# Conservation Area Advisory Committee

Meeting Date : 4 March 2013

| App No                                                                                         | Description/Address                                                                                                                                                                                                                                                                                            | Comment | Recommendation/Observation                                                                                                                 |
|------------------------------------------------------------------------------------------------|----------------------------------------------------------------------------------------------------------------------------------------------------------------------------------------------------------------------------------------------------------------------------------------------------------------|---------|--------------------------------------------------------------------------------------------------------------------------------------------|
| <br>A/16/13/CA | Co

Drawing Title
Plots 1 - 3
Plans, Sections and Elevations

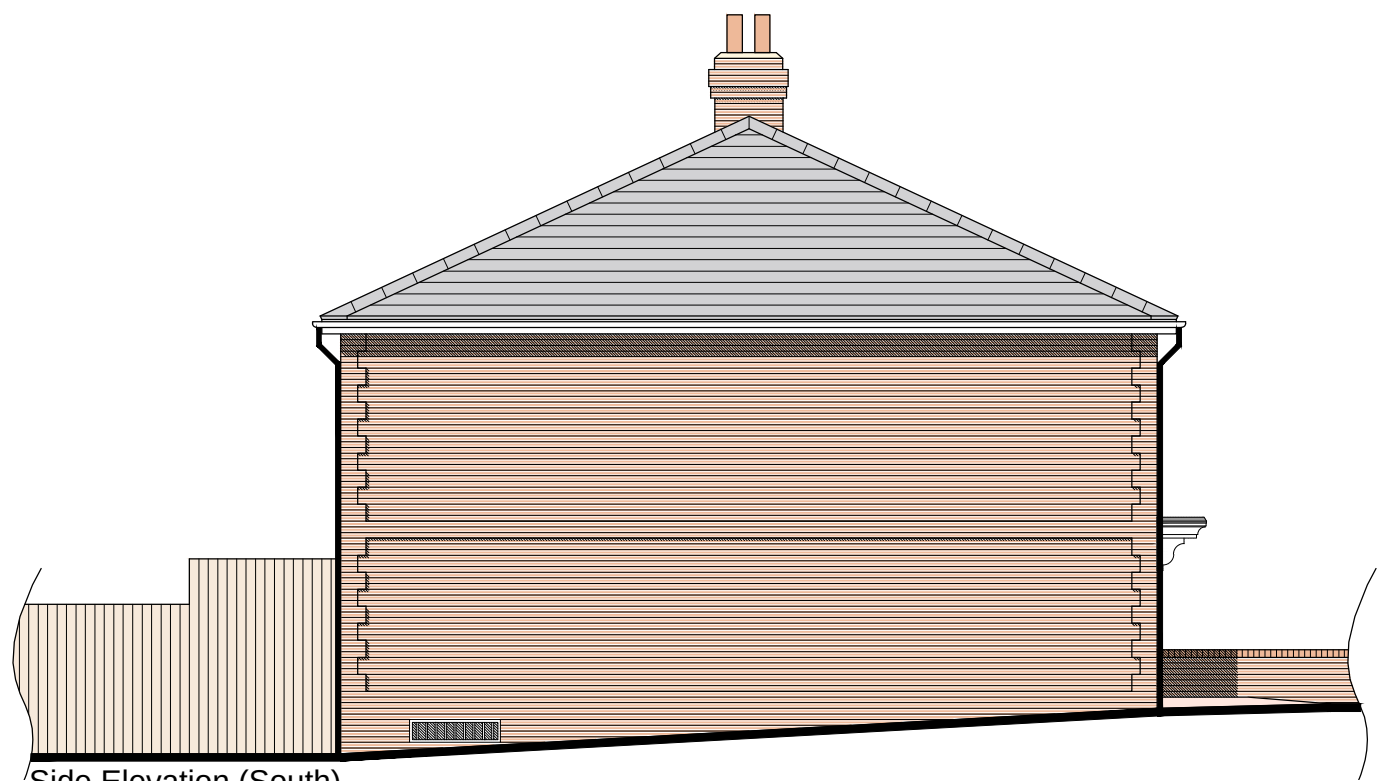
| App No                                                                                         | Description/Address                                                                                                                                                                                                                                                                                            | Comment | Recommendation/Observation                                                                                                                 |
|------------------------------------------------------------------------------------------------|----------------------------------------------------------------------------------------------------------------------------------------------------------------------------------------------------------------------------------------------------------------------------------------------------------------|---------|--------------------------------------------------------------------------------------------------------------------------------------------|
|                |                                                                                                                                                                                                                                                                                                                |         | Scale, design & massing does not enhance the C.A. The roof heights are too dominating particularly on the High St. & Water Lane frontages. |
